**City of Portland, Maine - Building or Use Permit Application**

<b>Proposed Use:</b> Single family home w/new 26'x26' 2 car garage w/ family room over	<b>Proposed Project Description:</b> Build new 26'x26' 2 car garage w/ family room over
---	--

**Dept:** Zoning      **Status:** Approved with Conditions      **Reviewer:** Jeanine Bourke      **Approval Date:** 11/08/2004

**Dept:** Building      **Status:** Approved with Conditions      **Reviewer:** Jeanine Bourke      **Approval Date:** 11/08/2004

PLOT PLAN / SITE PLAN

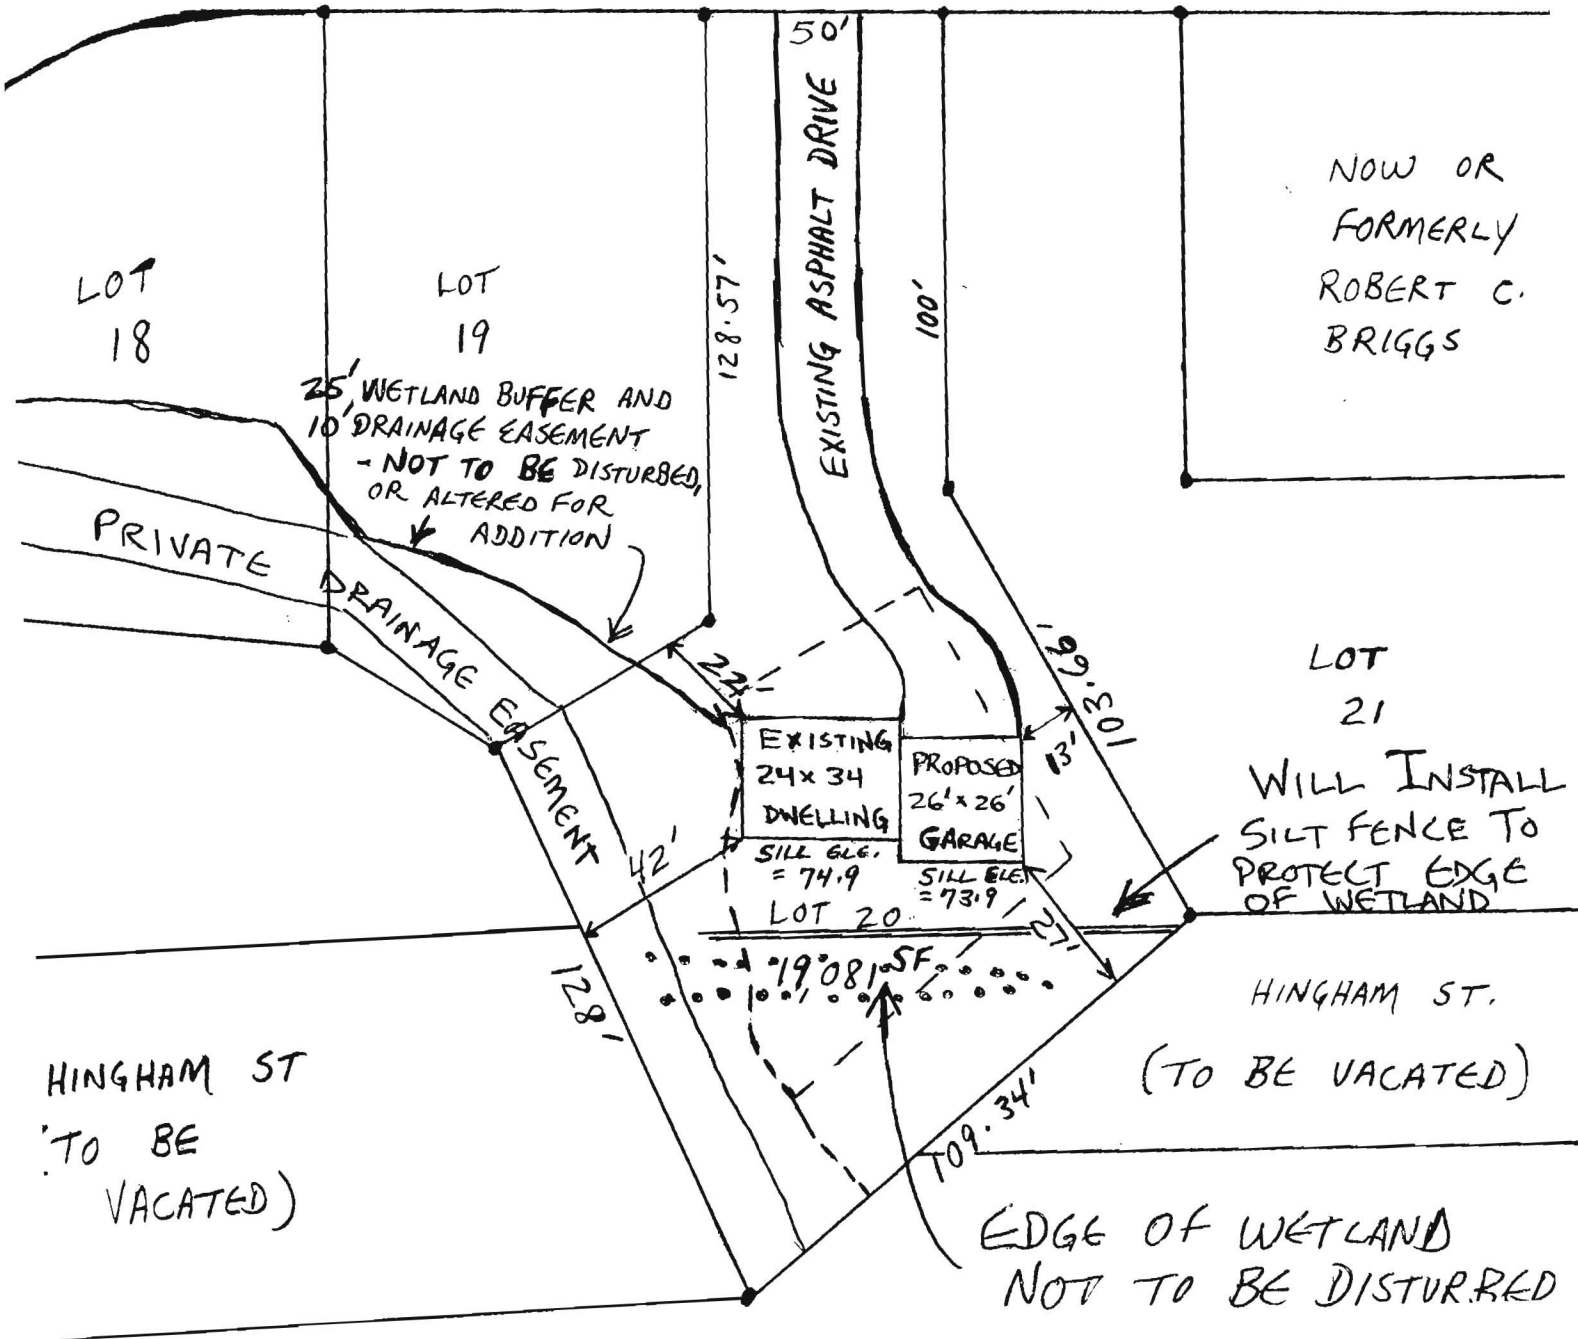
- 1) The full site plan review & fee for this garage was waived by this department and the DRC approved the site plan from the original subdivision with some minor changes.
- 2) As discussed w/Robert M., the front setback is very close to the 25' requirement. A survey may be required to verify compliance with the code.
- 3) This property shall remain a single family dwelling. Any change of use shall require a separate permit application for review and approval.

SIDE ELEVATION

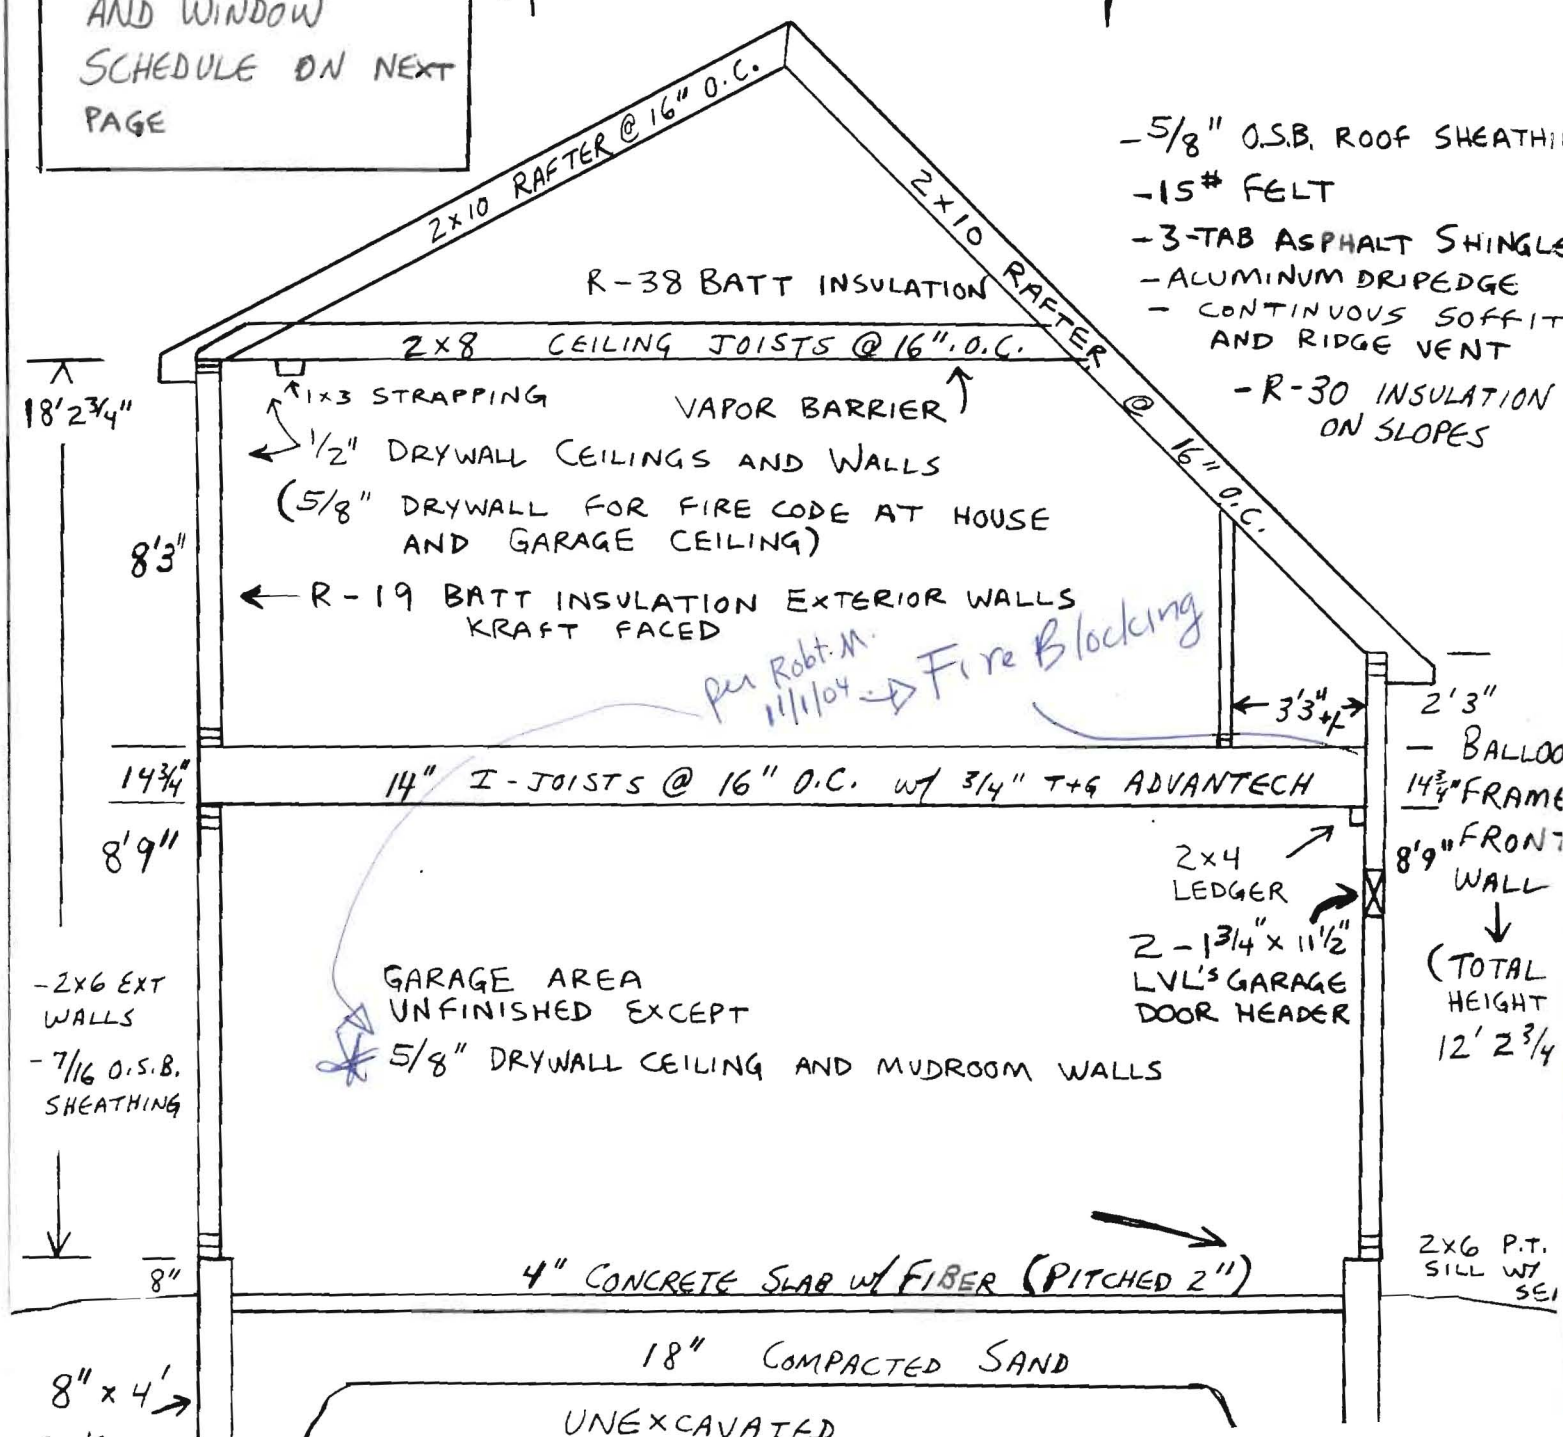
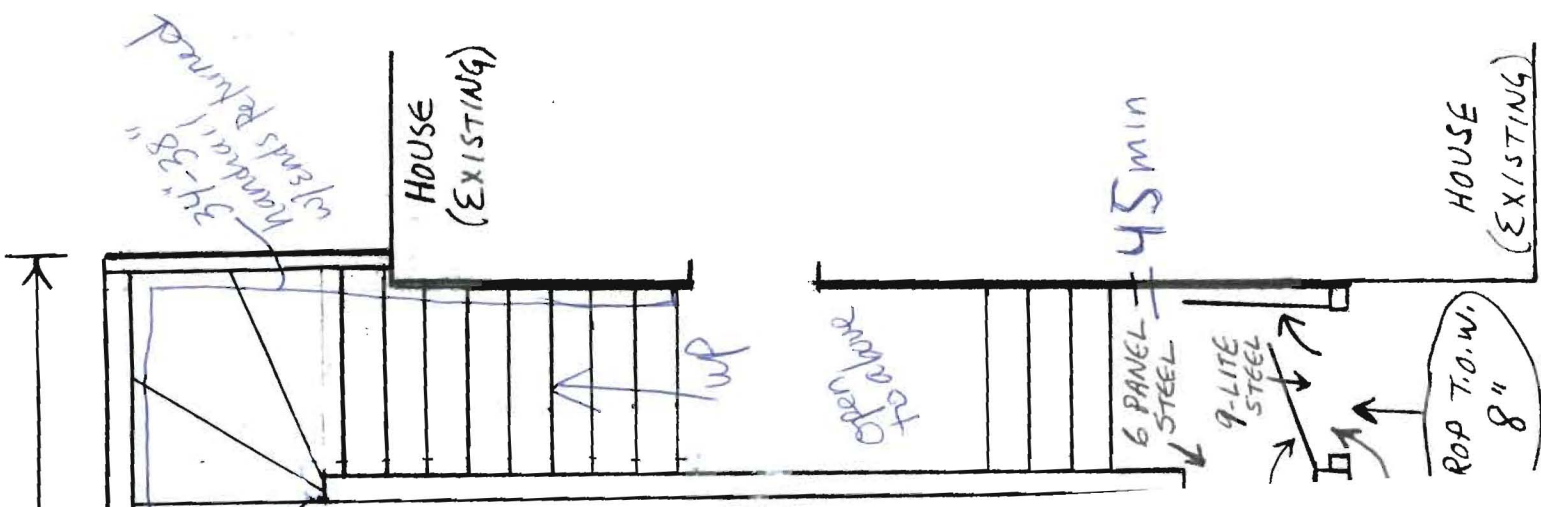
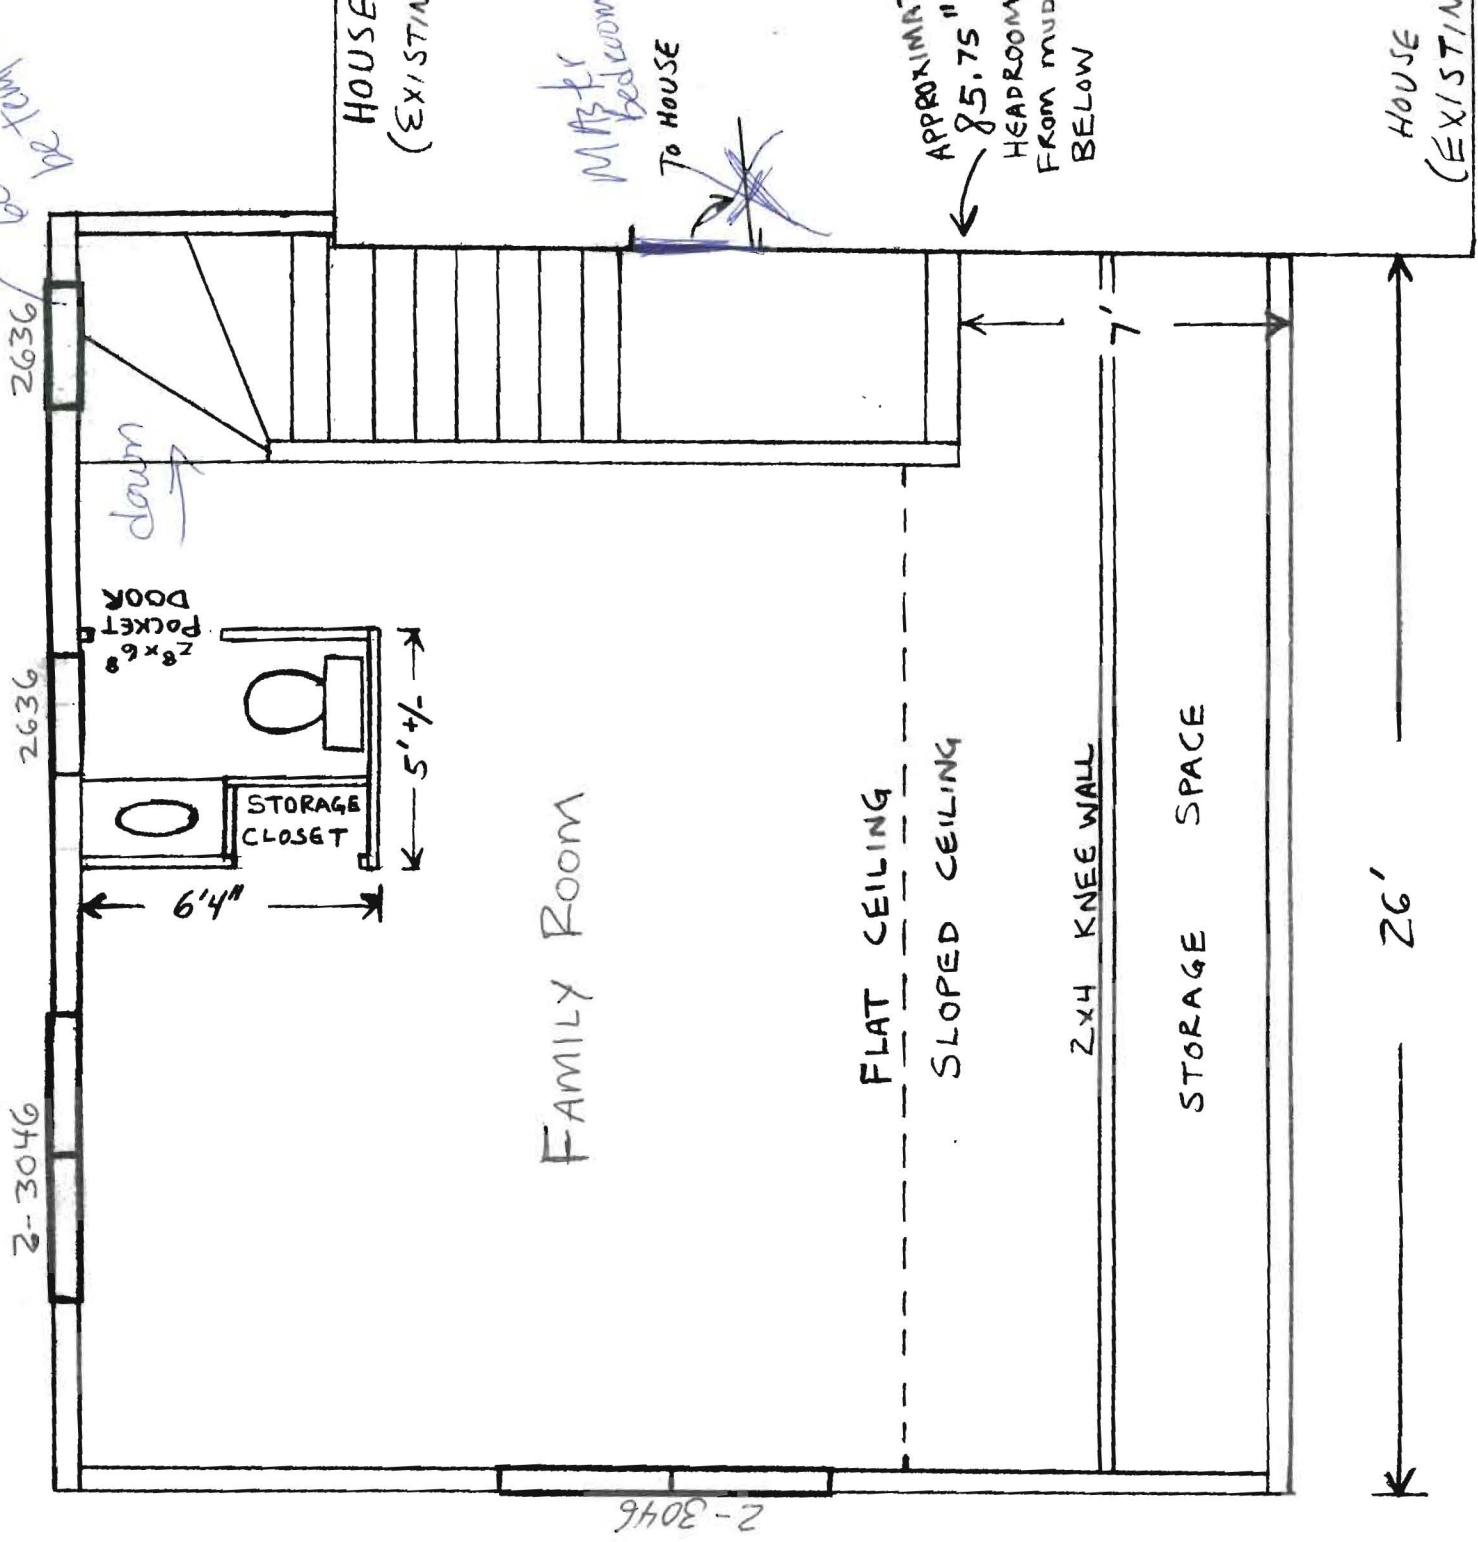
**Note:** 11/01/04 per phone call w/Robert M. Additional notes written on plans per the code.

- 1) A hardwired, battery back up smoke detector must be installed in the family room
- 2) The design load spec sheets for any engineered beam(s) must be submitted to this office.
- 3) Permit approved based on the plans submitted and reviewed w/owner/contractor, with additional information as agreed on and as noted on plans.
- 4) Separate permits are required for any electrical, plumbing, or heating.
